Board Order
ABP-313742-22

Planning Authority: Roscommon County Council

Planning Register Reference Number: DED515

- (a) Whether the carrying out of works for the improvement/refurbishment of the existing chalet is or is not development and, if deemed development, is or is not exempted development.
- (b) Whether the maintenance and renewal of the existing level access for parking and servicing of the subject chalet by motorised vehicle (referred to in the subject enforcement notice dated the 23rd day of February 2021 as the 'Raised Stone Platform') is or is not development and, if deemed development, is or is not exempted development.
- (c) Whether the clearing of scrub, under and overgrowth of self-seeded and other vegetation and replanting of grassland, native tree species and general landscaping is or is not development and, if deemed development, is or is not exempted development.

Client: EDVINAS CINGA
Drawing Title: Alignment drawing
Drawing Identifier: 21.17.MMA-A-205

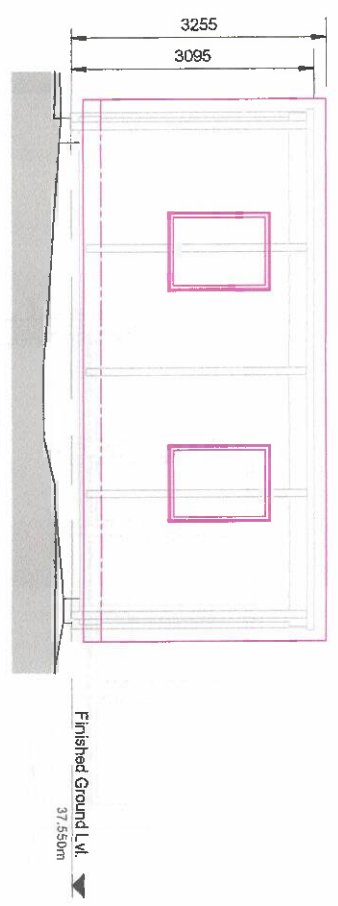
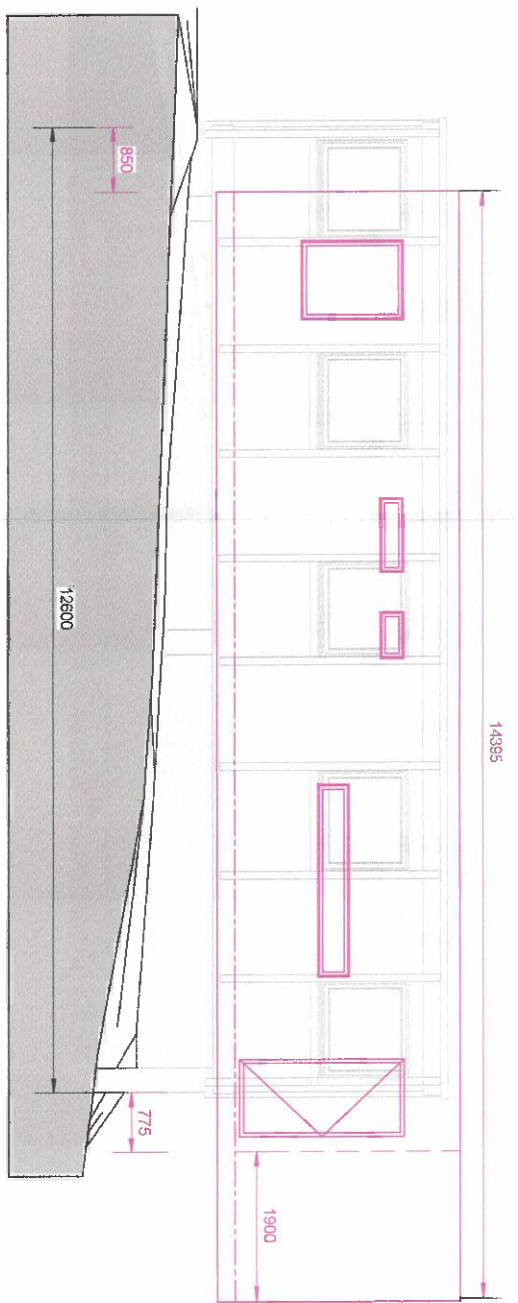
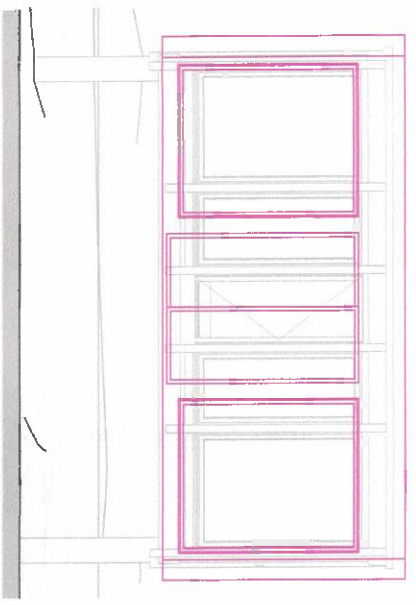
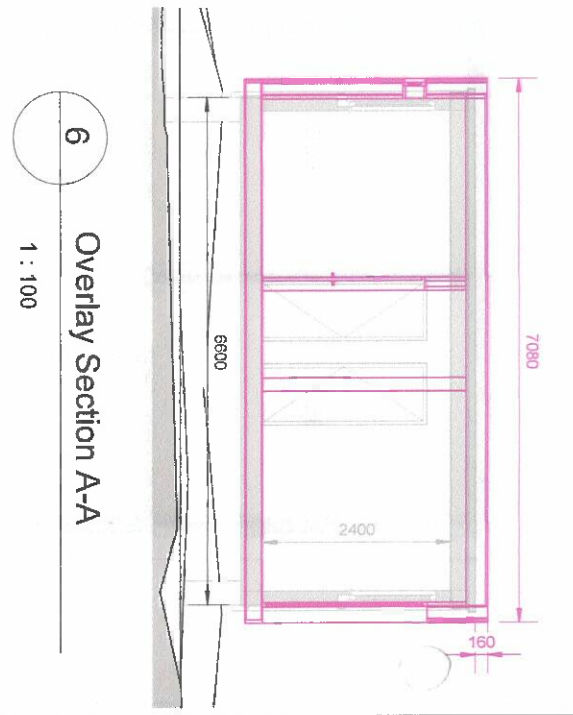
- (a) The carrying out of works for the improvement/refurbishment of the existing chalet results in a structure that is materially different in size and appearance to the previously existing structure on the site and does not accord with the provisions of Section 4(1)(h) of the said Act.

- (a) The carrying out of works for the improvement/refurbishment of the existing chalet,
- (b) The maintenance and renewal of the existing level access for parking and servicing of the subject chalet by motorised, and
- (d) The formation of new boundary treatment to define the chalet boundary, not exceeding 1.2 metres in height, and a new gate not exceeding two metres.
